CITY OF ELLENSBURG

Memorandum

Date: March 17, 2021
To: Jeremy Johnston, Planning Official
From: Craig Jones, Development Coordinator *CJ*
Through: Derek Mayo, City Engineer *DKM*
Re: Bull Rd & Umptanum Rd – The Bull Ranch – EX21-001

The following are the Public Works Pre-App comments for the proposed The Bull Ranch on the east side of Bull Rd at Umptanum Rd.

W
A
T
E
R

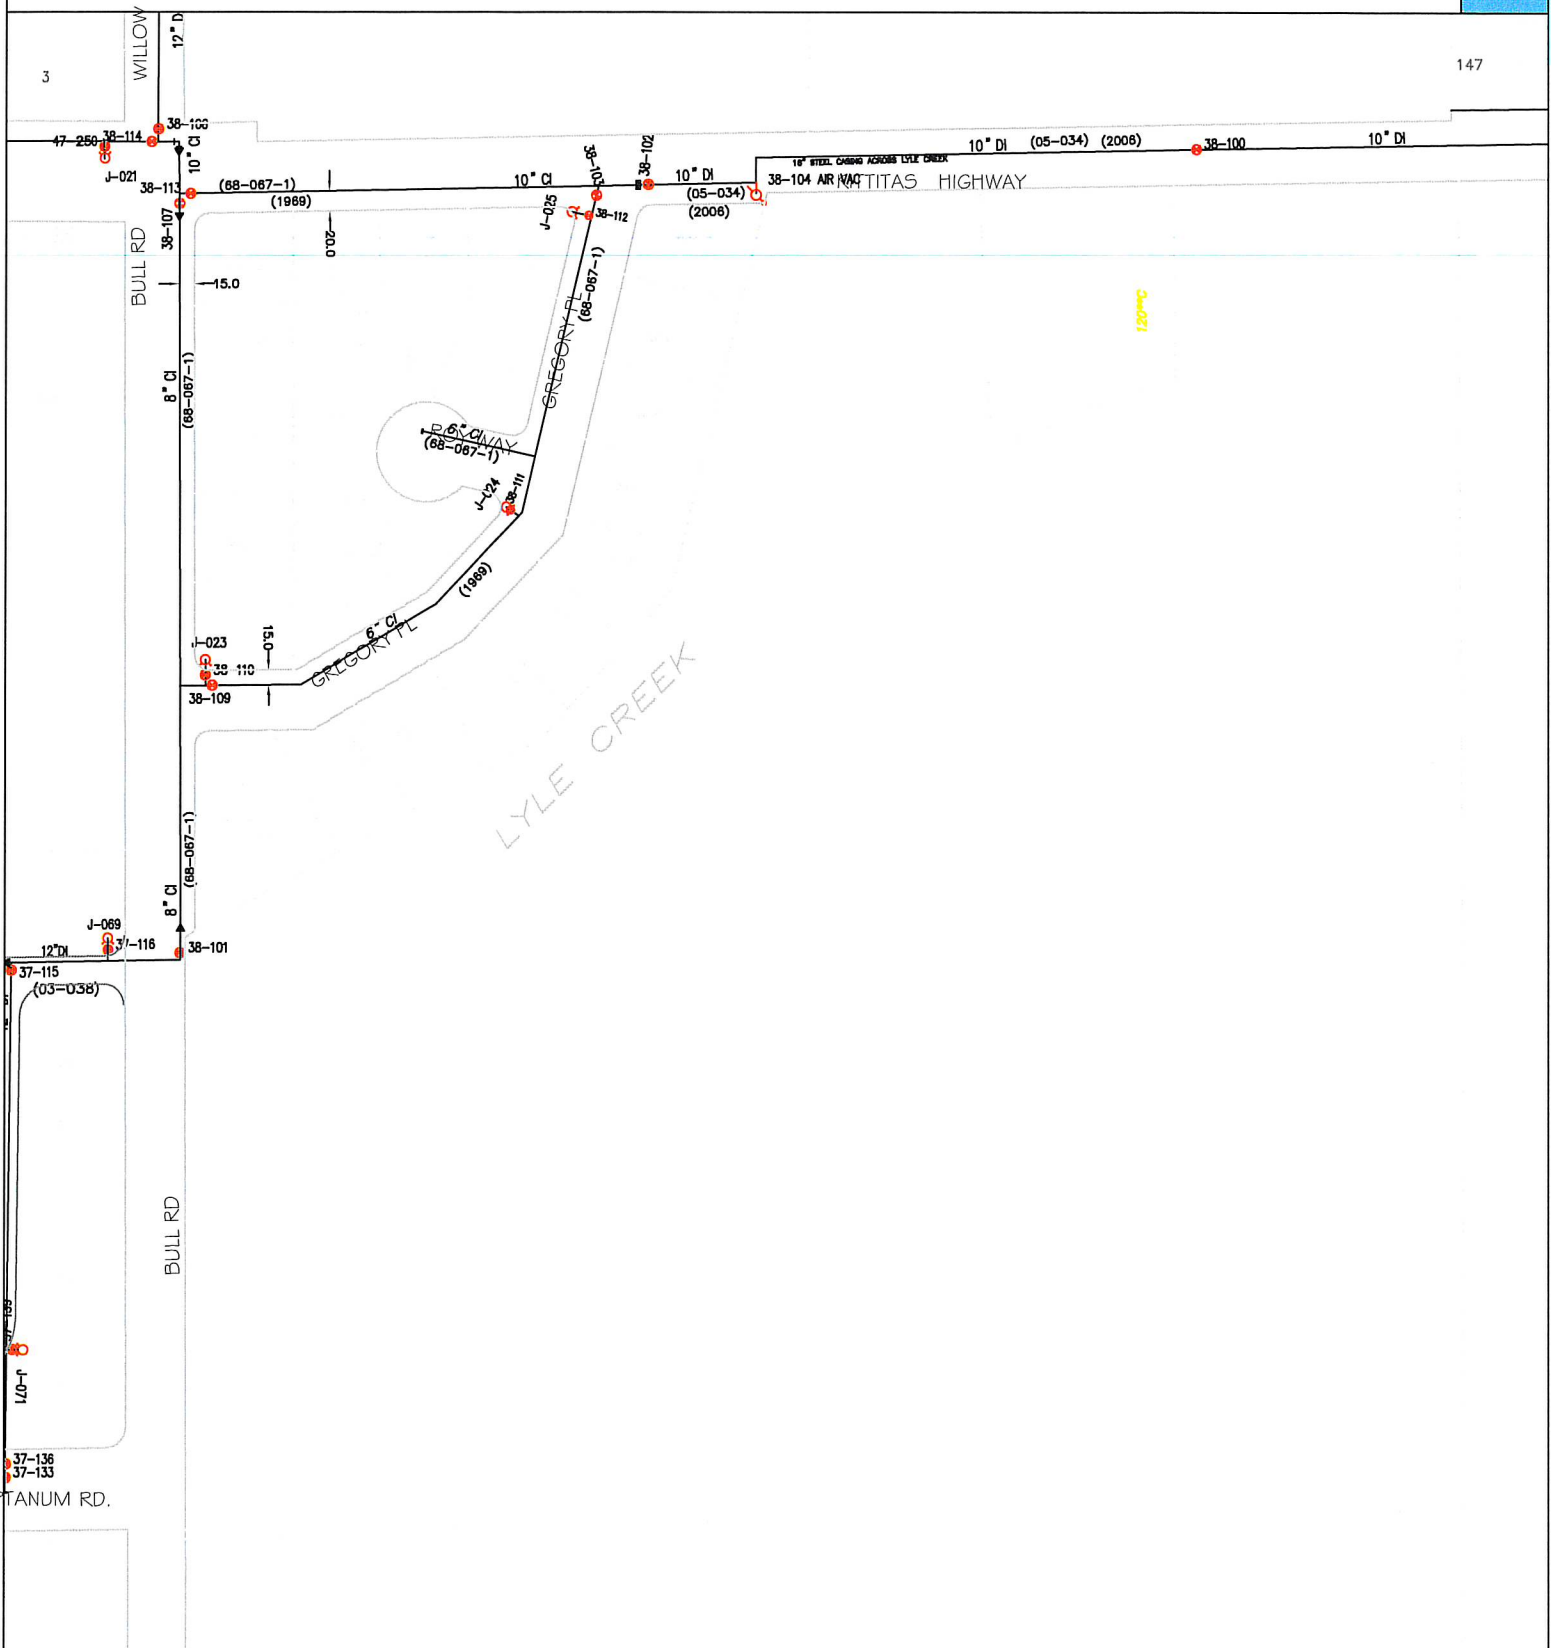
The water mains available to serve this development are a 10" Ductile Iron main that runs in Kittitas Highway and an 8" stub is being installed at Umptanum Rd extension as part of the City's Bull Rd project. The developer will need to build an 8" water main on all the proposed interior roads. Each lot will need a separate water service. The maximum number of lots that can be served by one water connection is 40 lots. The water system will need to be looped between Kittitas Hwy and Umptanum Rd. See attached utility map.

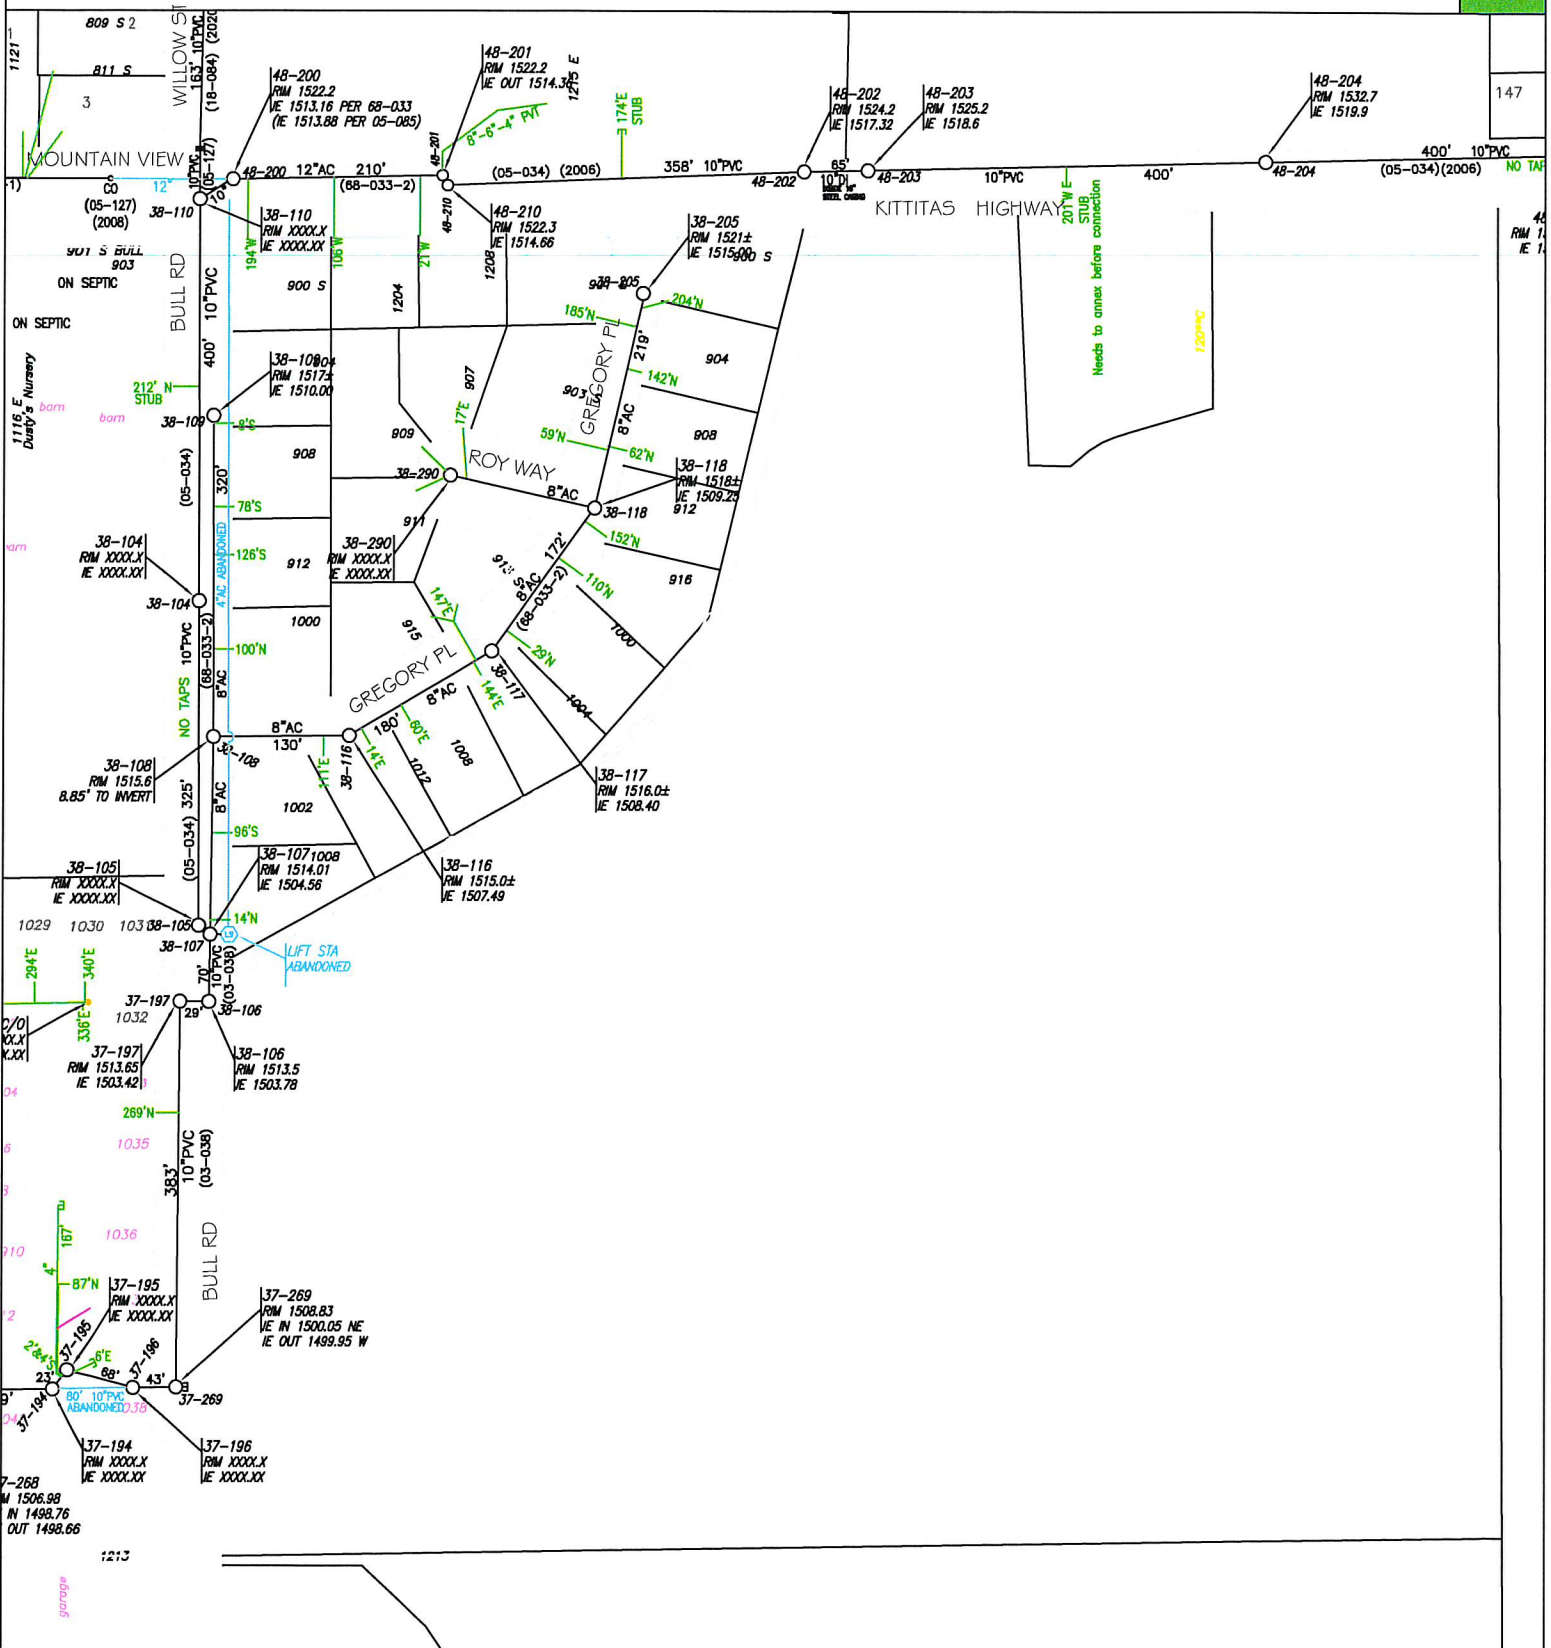
The sewer mains available to serve this development are a 10" PVC main in Kittitas Hwy and an 8" stub is being installed at Umptanum Rd extension as part of the City's Bull Rd project. The developer will need to install 8" sewer mains on the interior roads and side sewer stubs to each lot. See attached utility map.

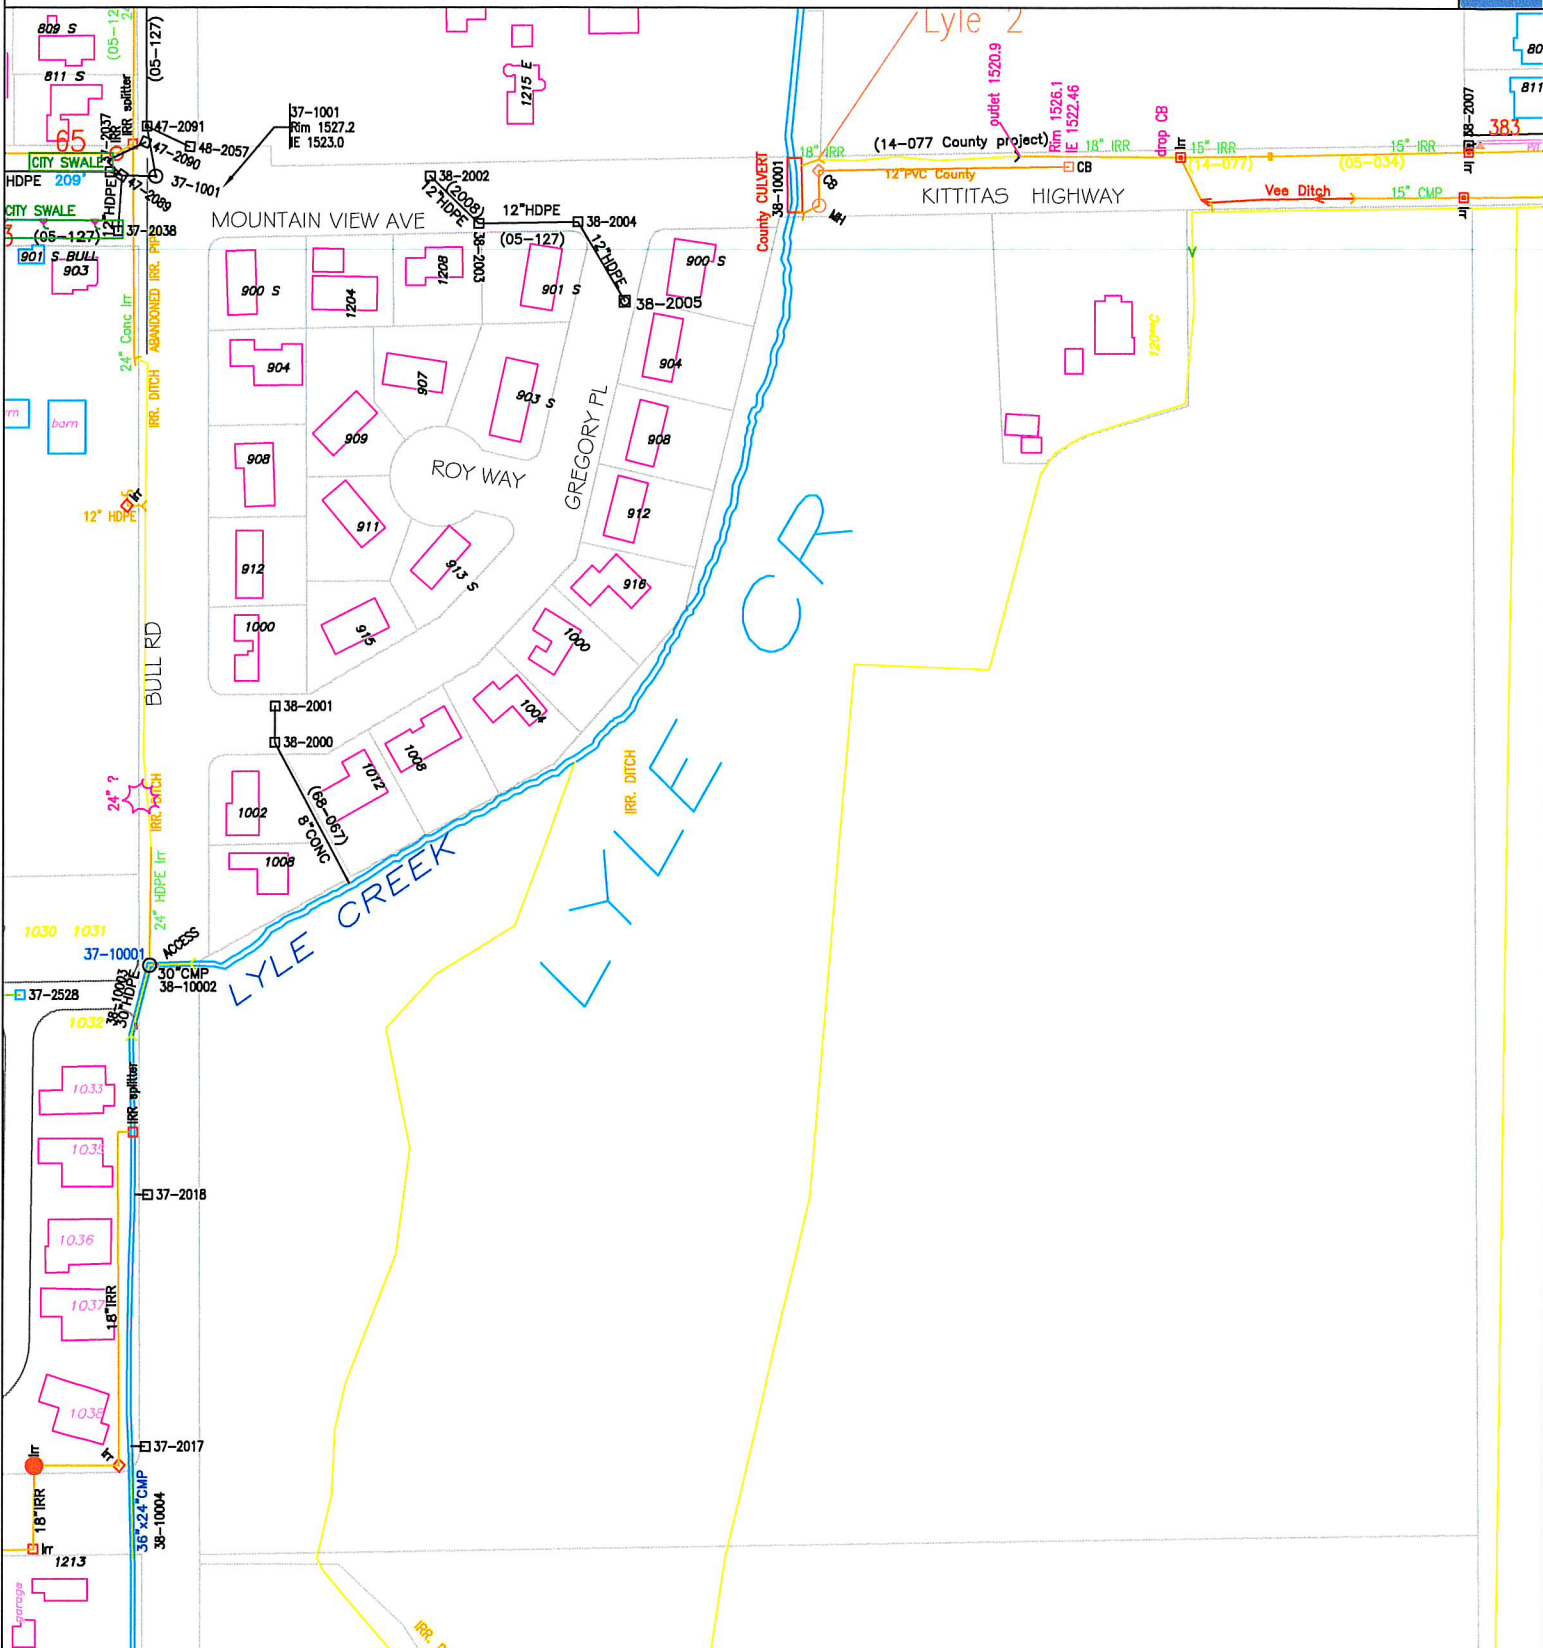
There is no storm system available for a direct discharge. The existing road side ditches will need to be conveyed across the frontages of the property. All storm facilities will need to be designed so they will not be inundated with ground water. Your engineer will need to verify groundwater during peak irrigation season to confirm the project will not be effected by it. See attached utility map.
